DECISION DELEGATED TO HEAD OF PLANNING

Application No: H16-0803-21 **Applicant:** Mr I Buckley

Proposal: Extensions and alterations and replacement septic tank

Location: 145 Bourne Road Spalding

Site Plan (Scale 1 : 100)

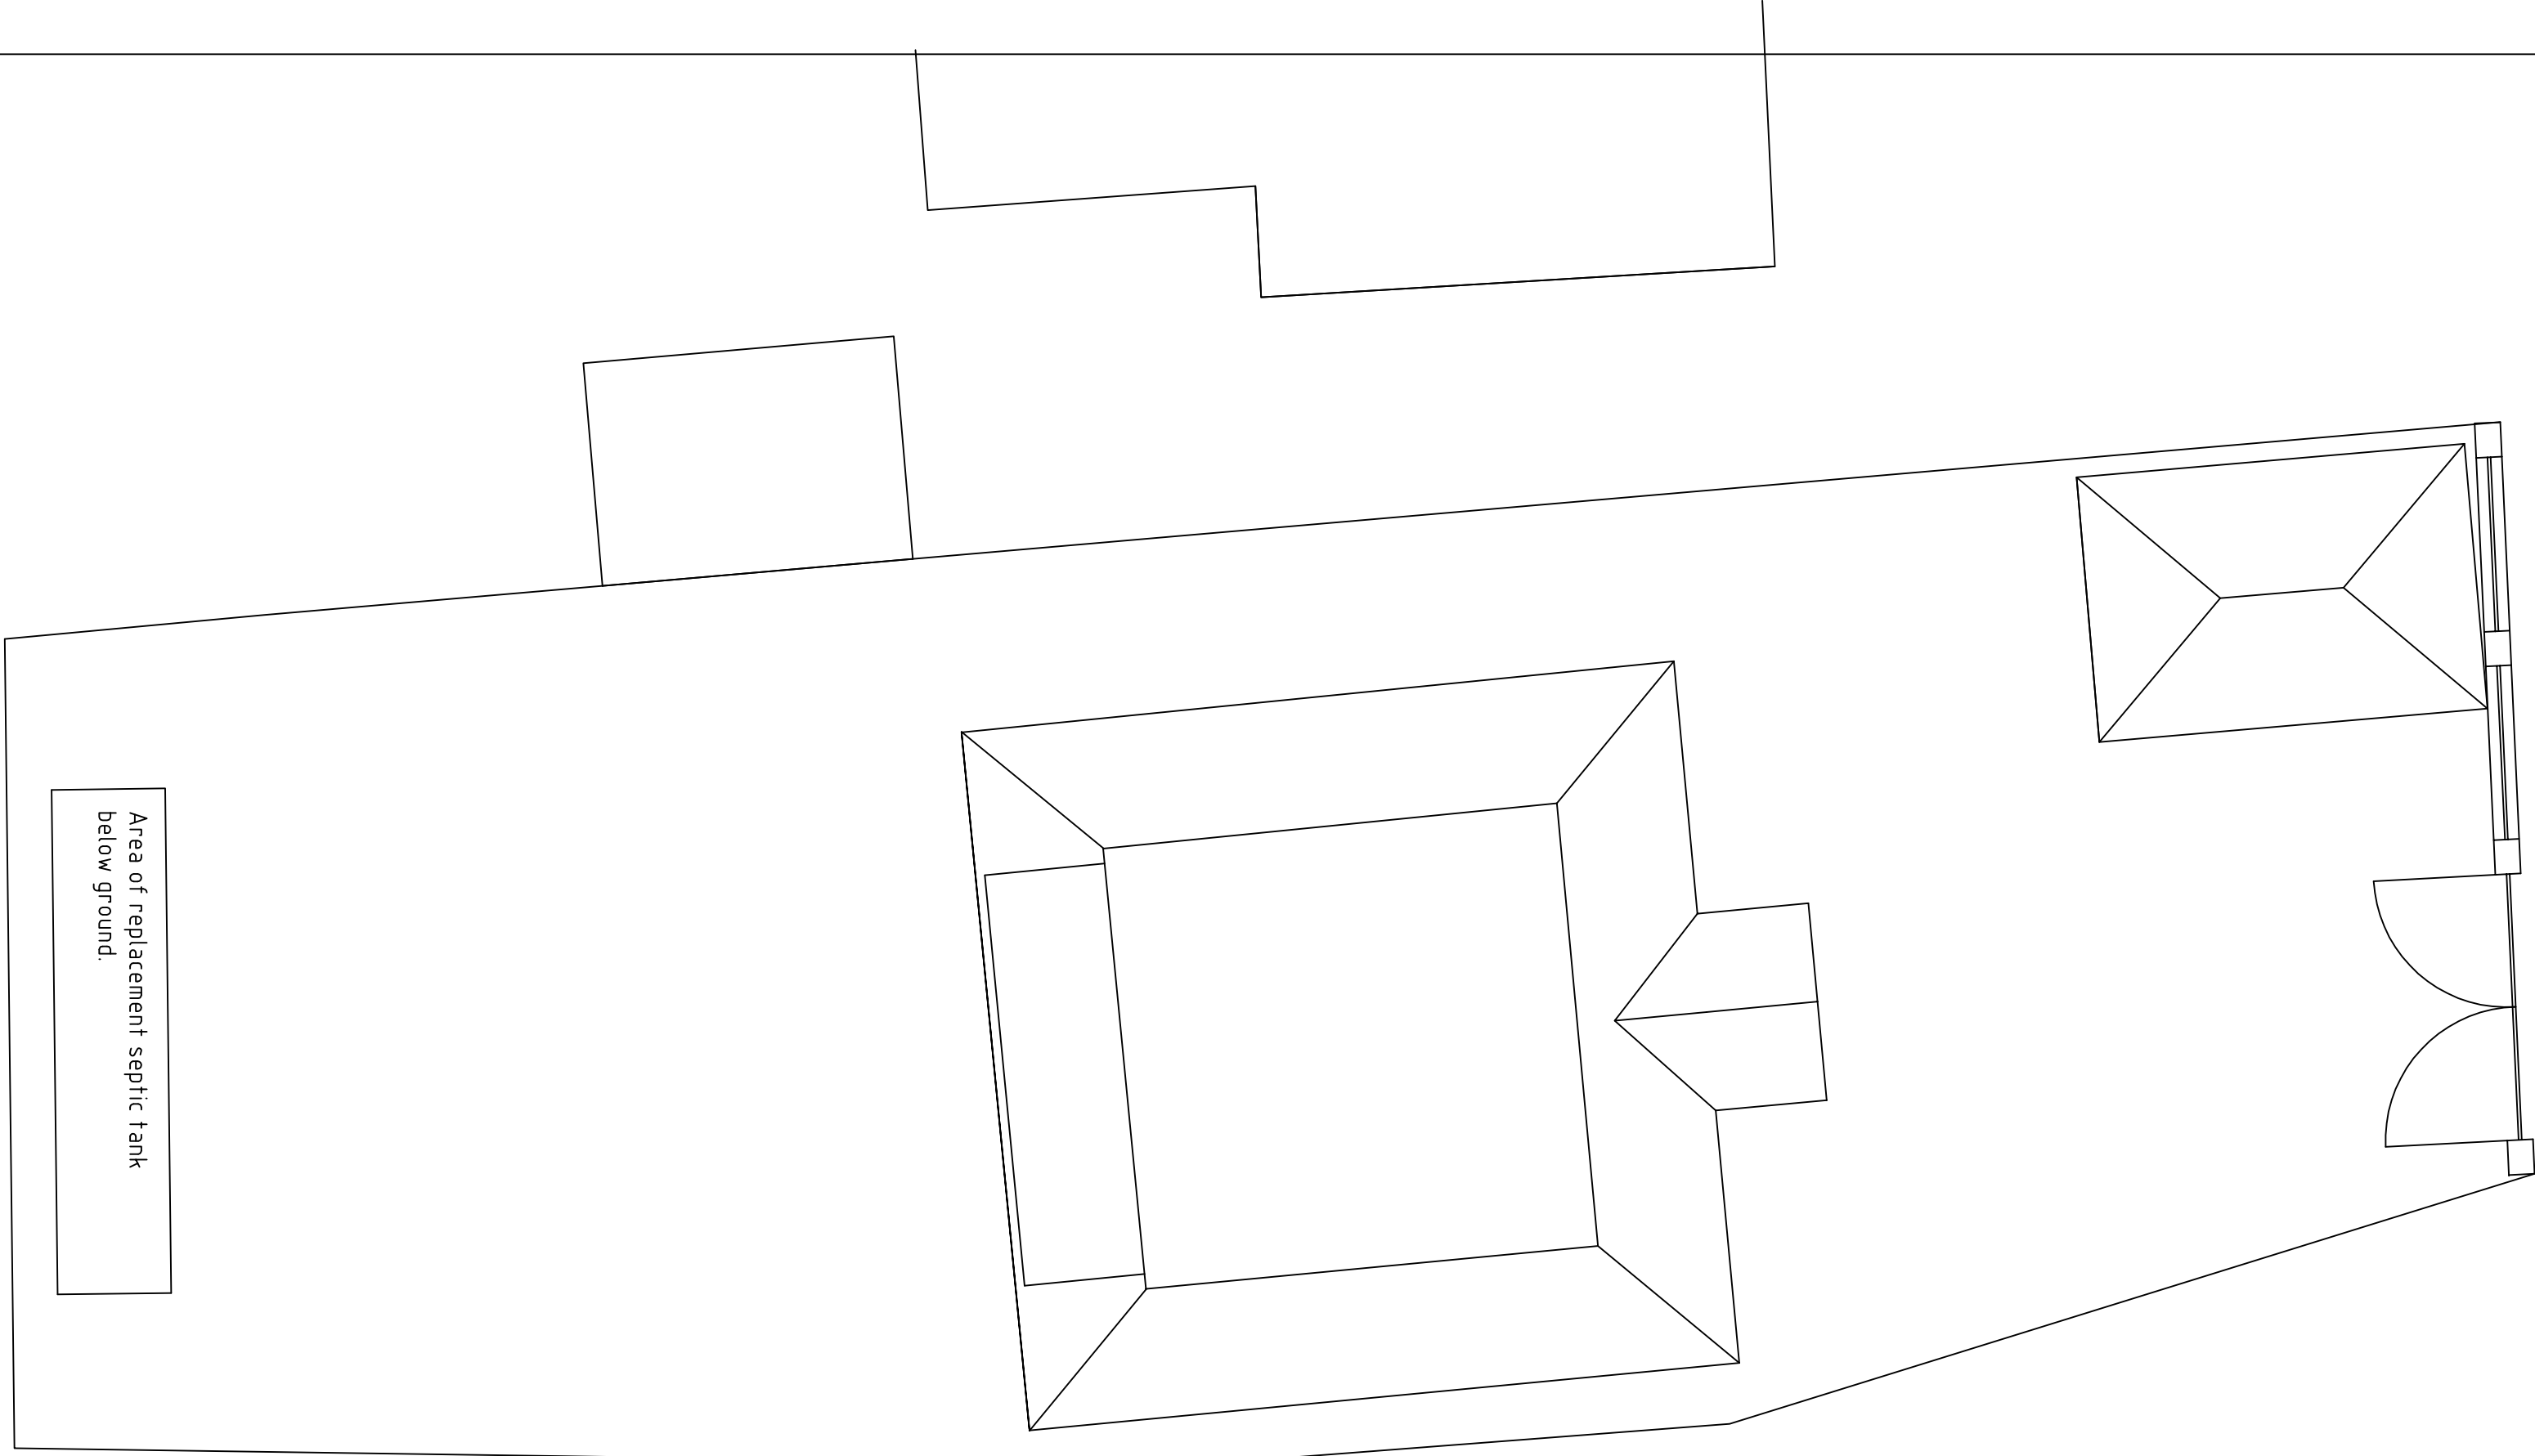
The Board insist that the package treatment plant is installed no closer towards the drain brink than the position of the existing septic tank.

The proposed garage will be positioned to the front of the property (adjacent to the front boundary), which will accommodate two cars. The garage will measure approx. 6.3m by 4.3m and will also have a hipped roof similar to the design of the roof on the dwelling. It will be visually in keeping with the dwelling and, although sited well forward of the property and any other buildings fronting Bourne Road, would be well screened/backdropped by existing hedging.

Site Plan (Scale 1 : 200)

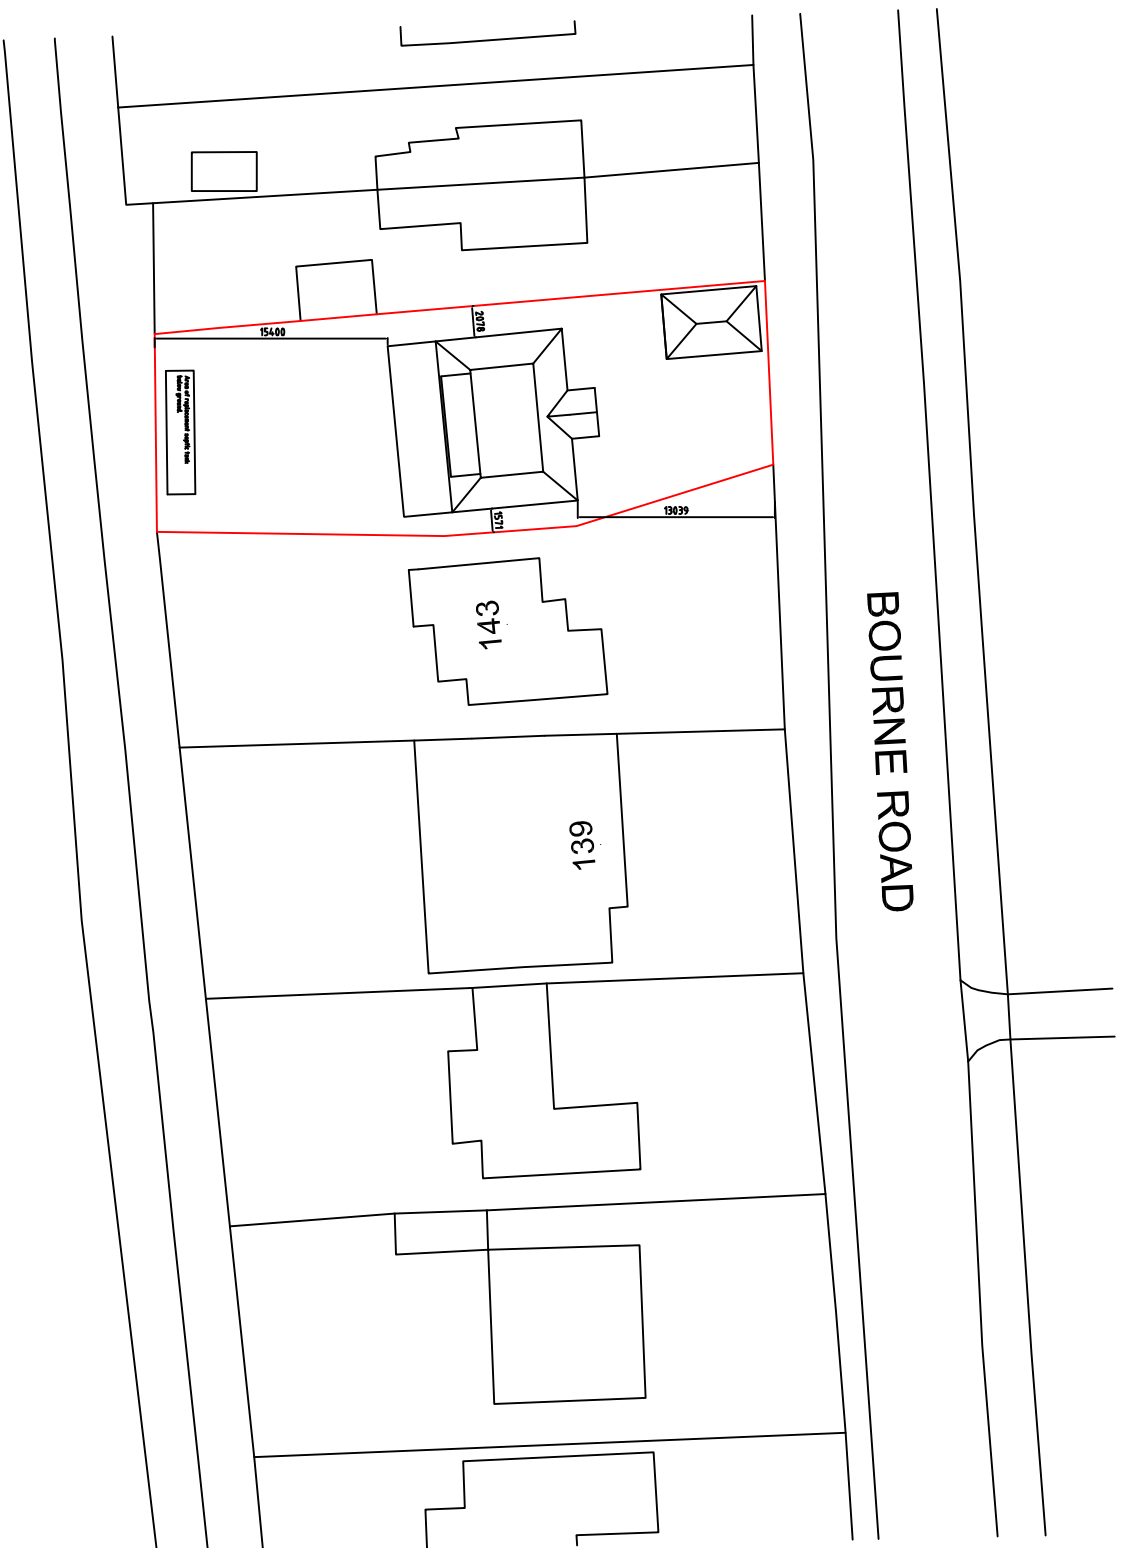
Discussed concerns with resident that dimensions of the proposal are greater than the plot size. Also the block plan suggests that the rear extension will not go beyond the building line of number 143 but from looking at Google maps I think it will. In this case the extension will be intrusive to number 143 in terms of lack of privacy and overshadowing. Can you make a condition that the extension does not pass the building line of number 143 or extend any closer to the property boundary.

Objections have been raised about the dimensions of the proposal being inaccurate, however, there is no reason to believe that the plans are incorrect and overall the scale is considered to be in keeping with the size of the plot and the surrounding character of detached dwellings along Bourne Road.
